19 October 2012

RE: Submission to MP09_0066 MOD 3 Thomas Street Carpark, Chatswood

A-0100 C  
SECTION 75 W SUBMISSION

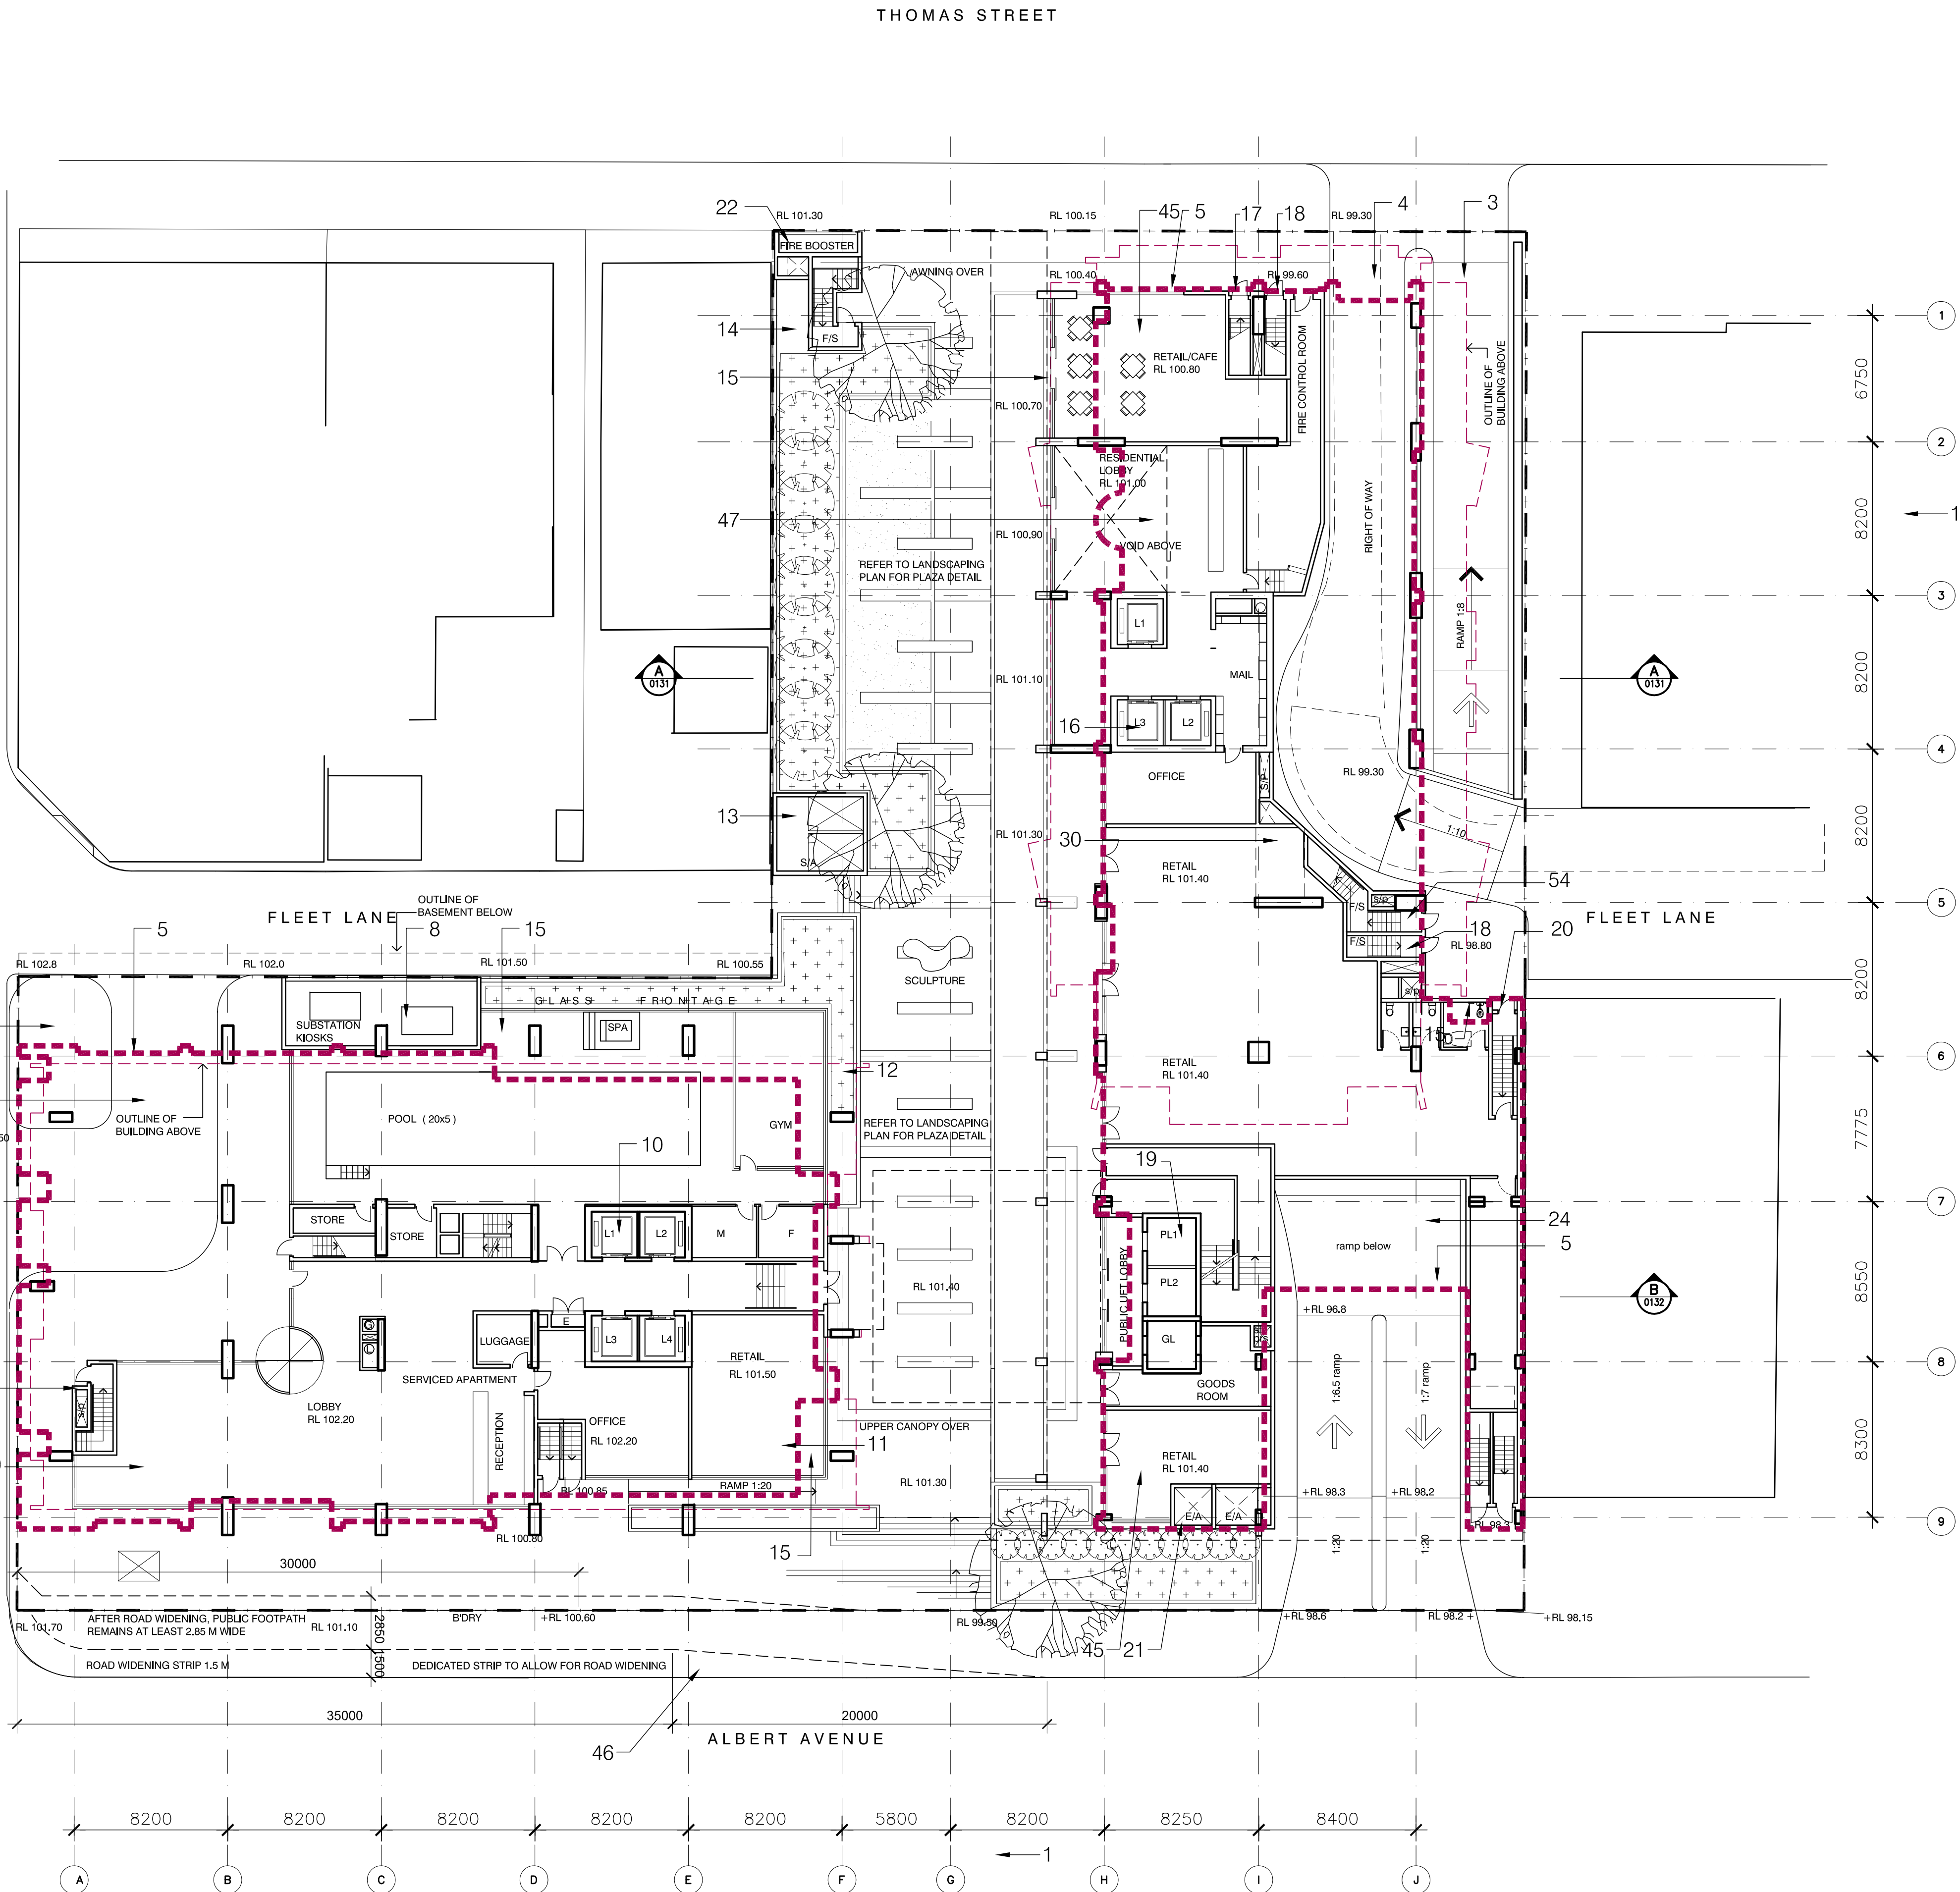
Since the sale of the carpark located next door to 12 Thomas St., the access that was previously available to the disabled ramp from Thomas Street has been blocked. There used to be a walkway that was protected by two railings that went from Thomas St. to Fleet lane along our building side of the carpark. Not having this access has made it very difficult for my clients to access the ramp that is located at the back of the building in Fleet Lane.

The changes to the ROW proposed to the development mean that the potential danger for my clients with disability significantly increases.

The tunnel proposed between Fleet Lane and Thomas Street is a concern as there are many questions that need to be addressed including pedestrian security and safety (lights, rubbish, broken glass and loiterers.)

It is not clear to me how, upon completion of the public carpark, how will my disabled clients get to 12 Thomas St?
